CITY OF ALBUQUERQUE

February 6, 2023

**RE: Ventana Square – Tract H-6B-1
Grading and Drainage Plan
Engineer's Stamp Date: 09/23/22
Hydrology File: B10D003C3C**

GRADING AND DRAINAGE PLAN

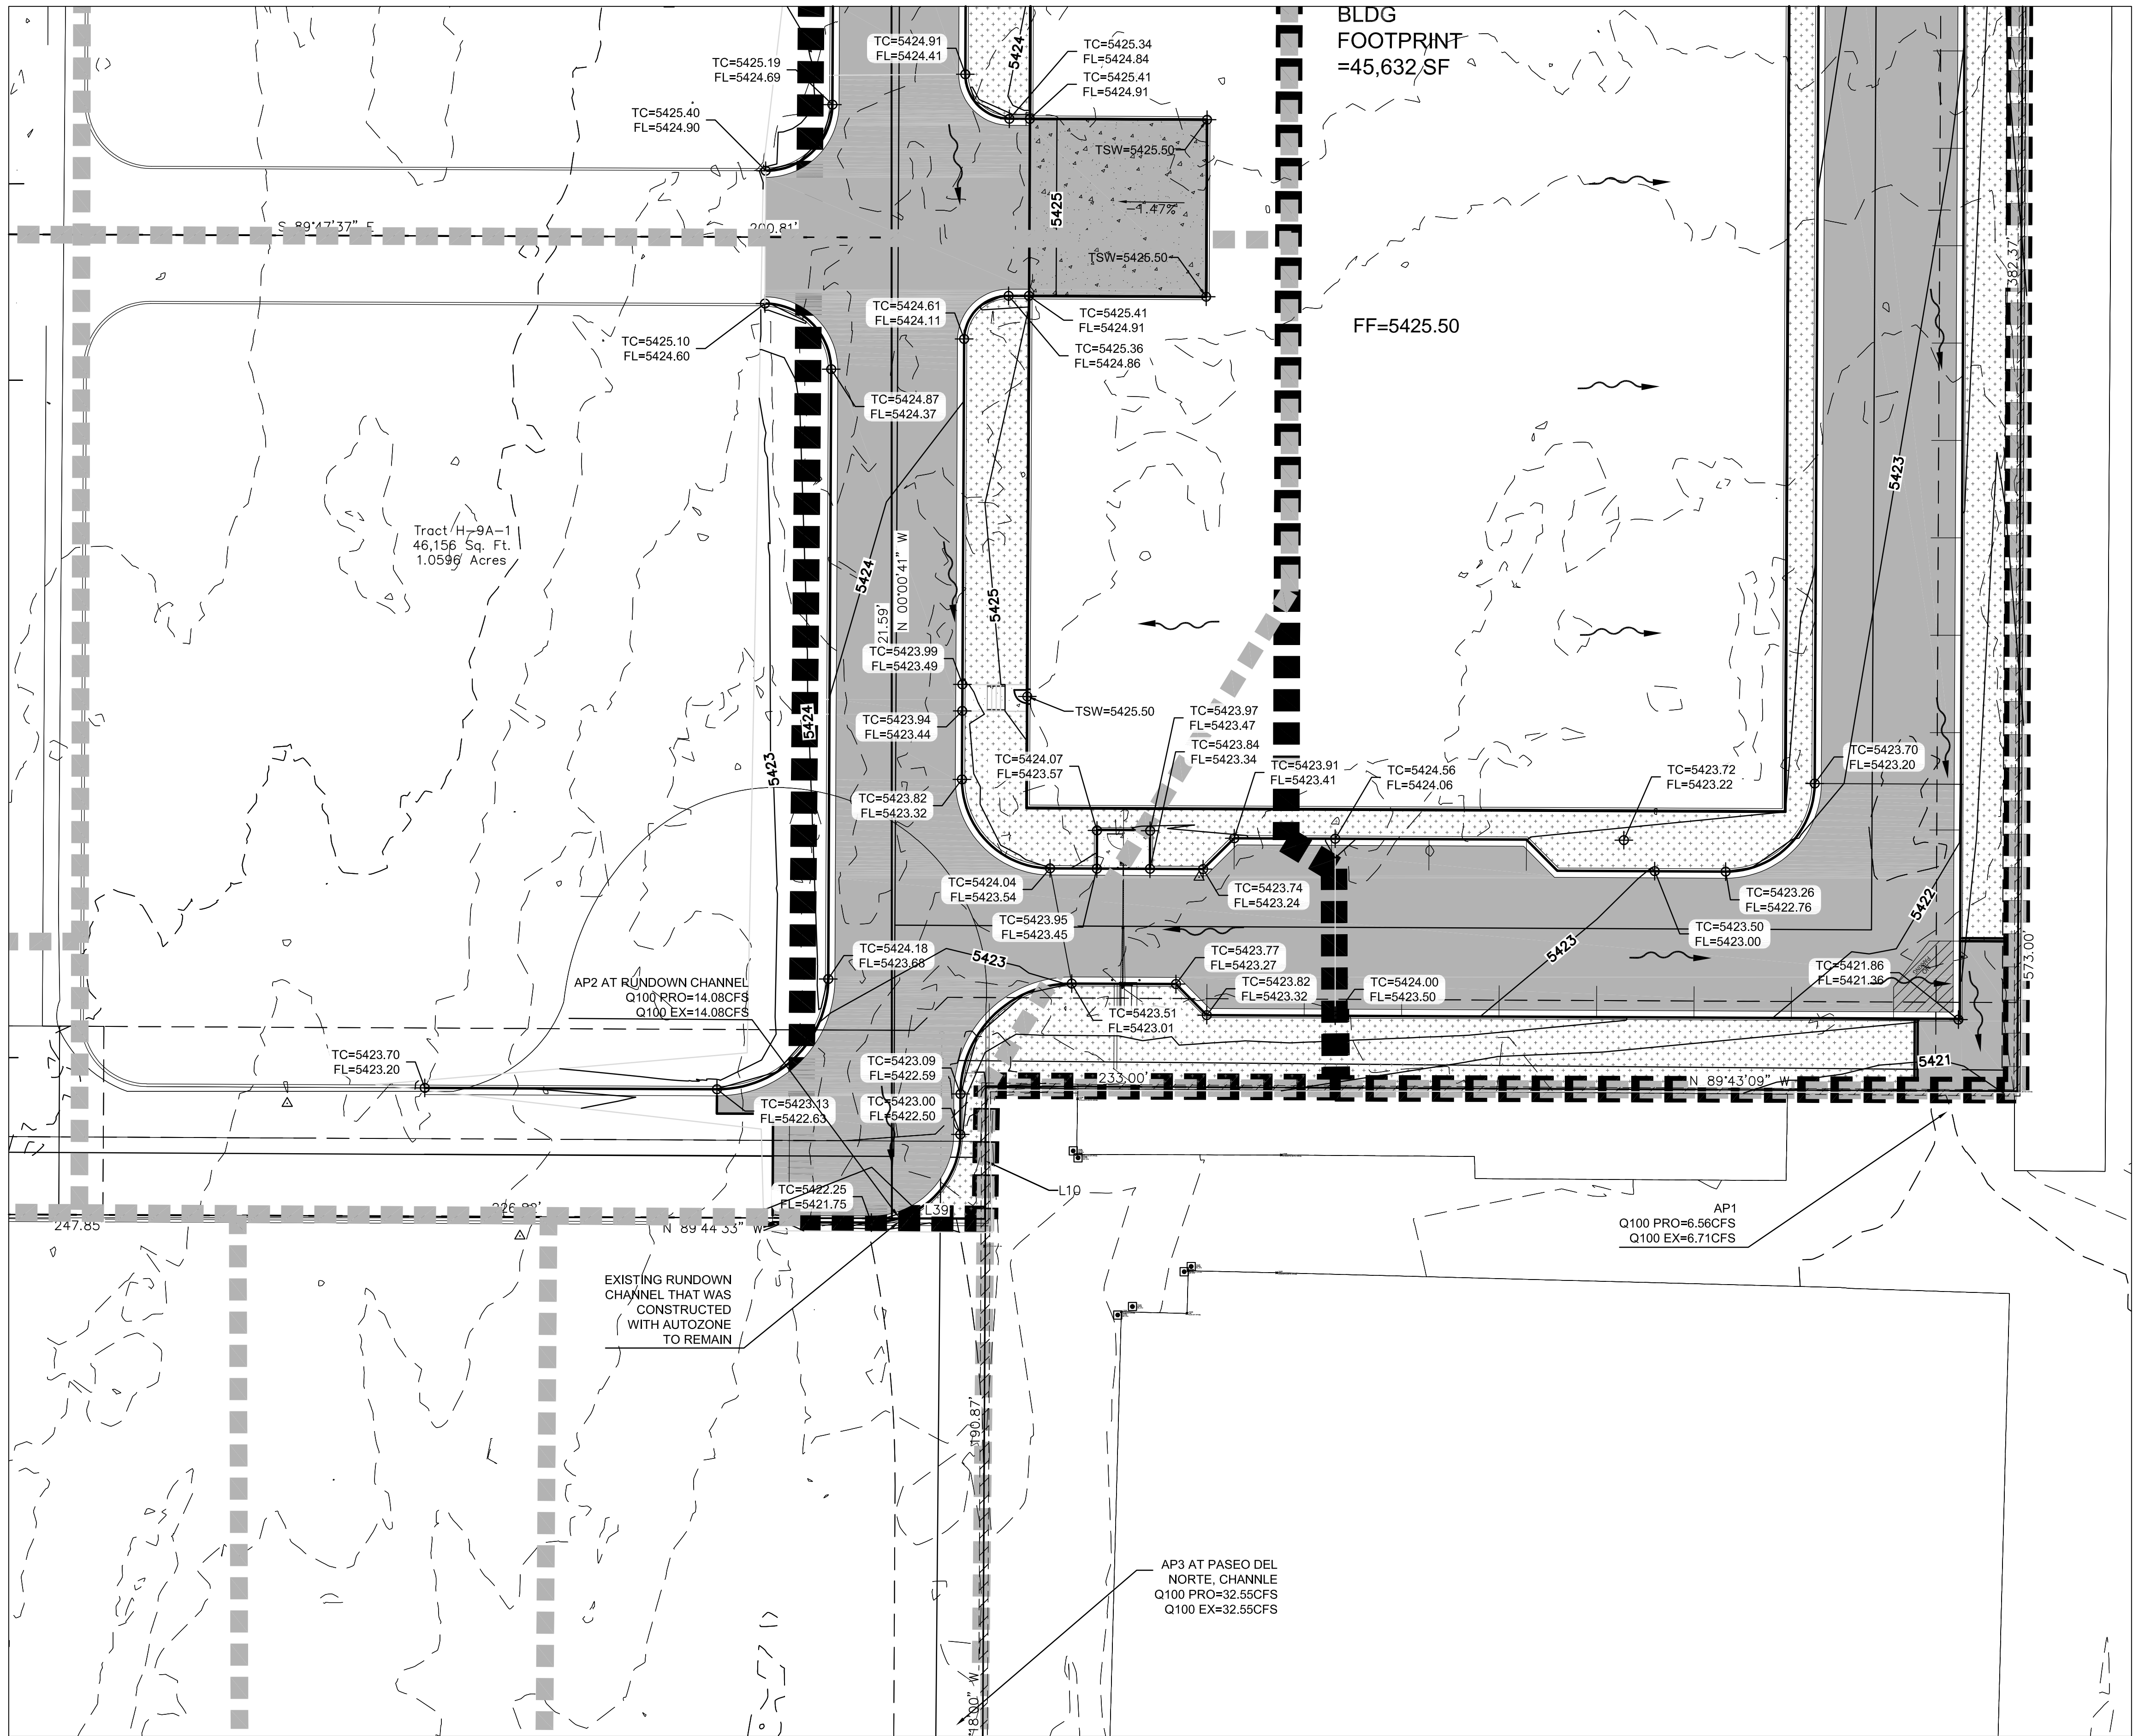
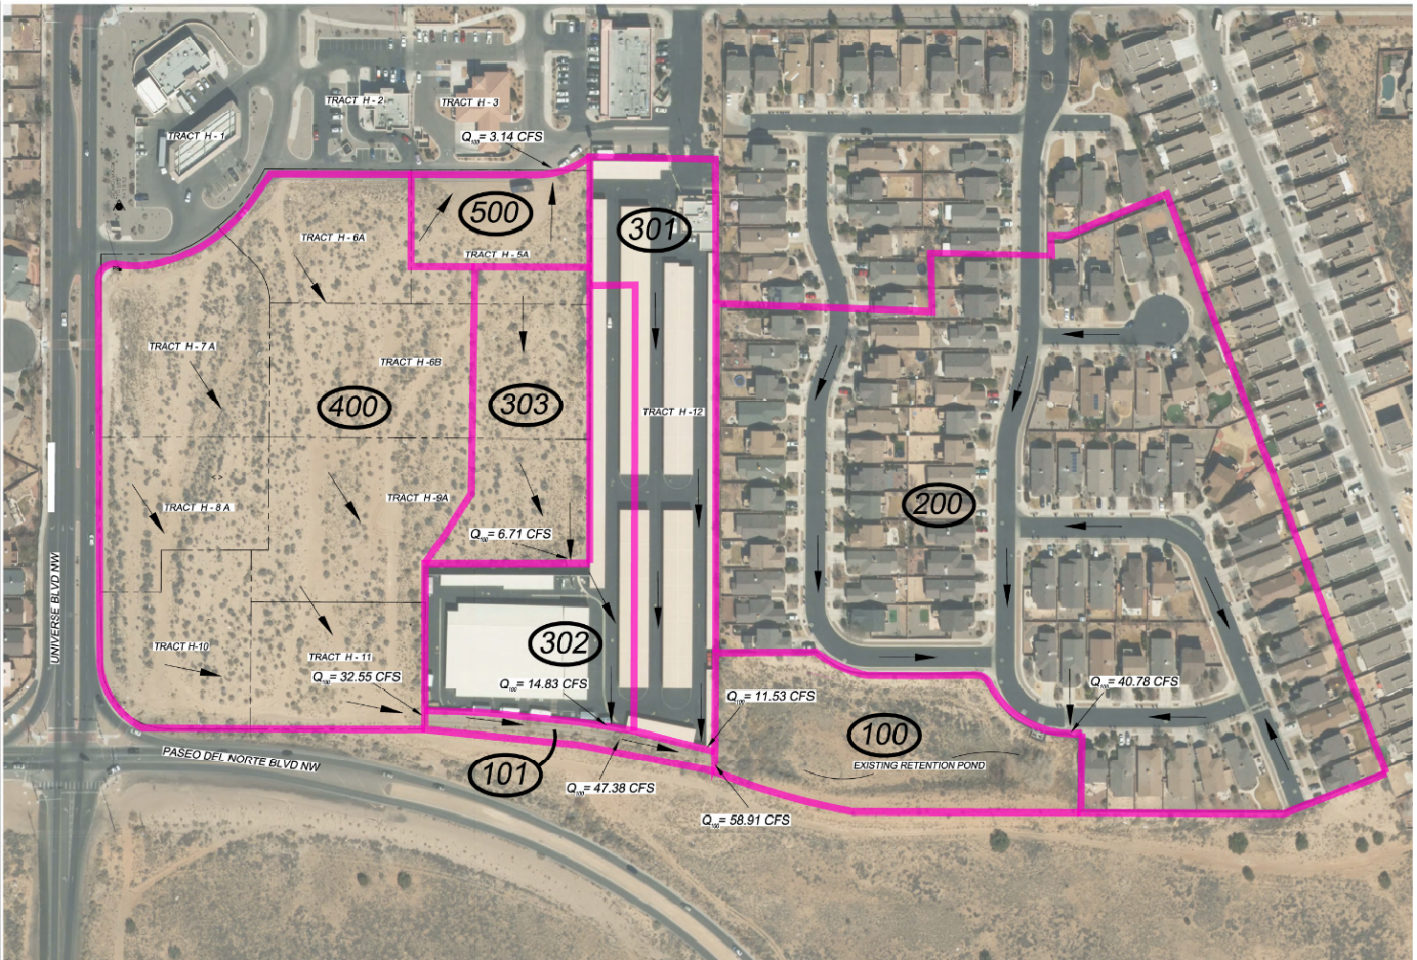
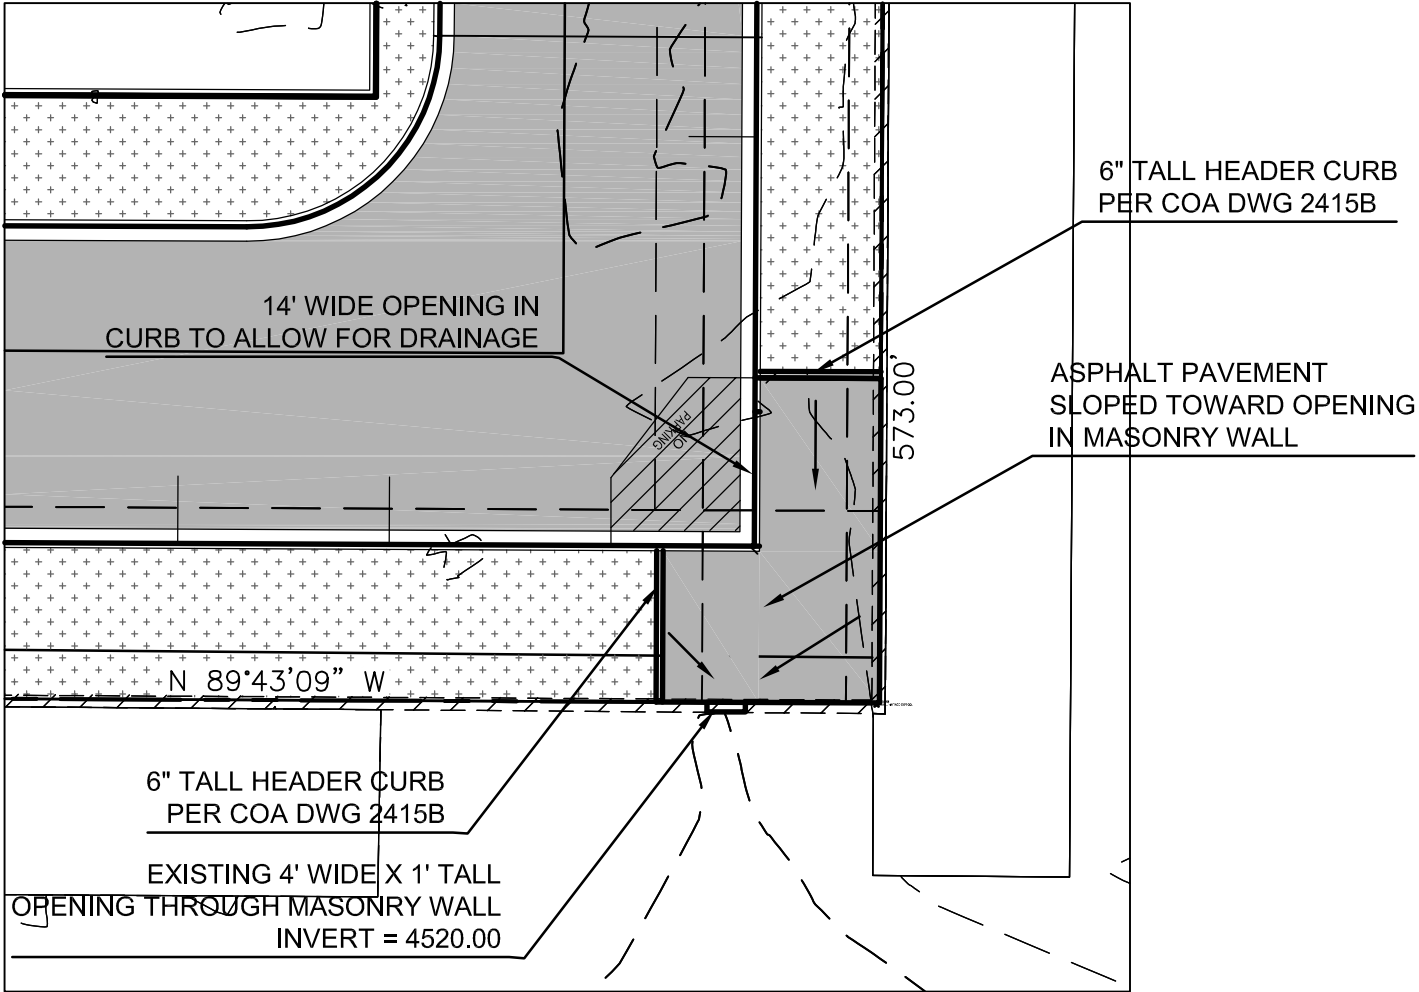
1. According to the stamped approved Drainage Management Plan with engineer's stamp date 07/30/21, This project was to drain to the west and not be included within the designed 14.08 cfs that drains through an existing swale to the concrete channel which ultimately discharges into the temporary retention pond.

Please adjust Basin C's drainage pattern and drainage calculations for this site to reflect this.
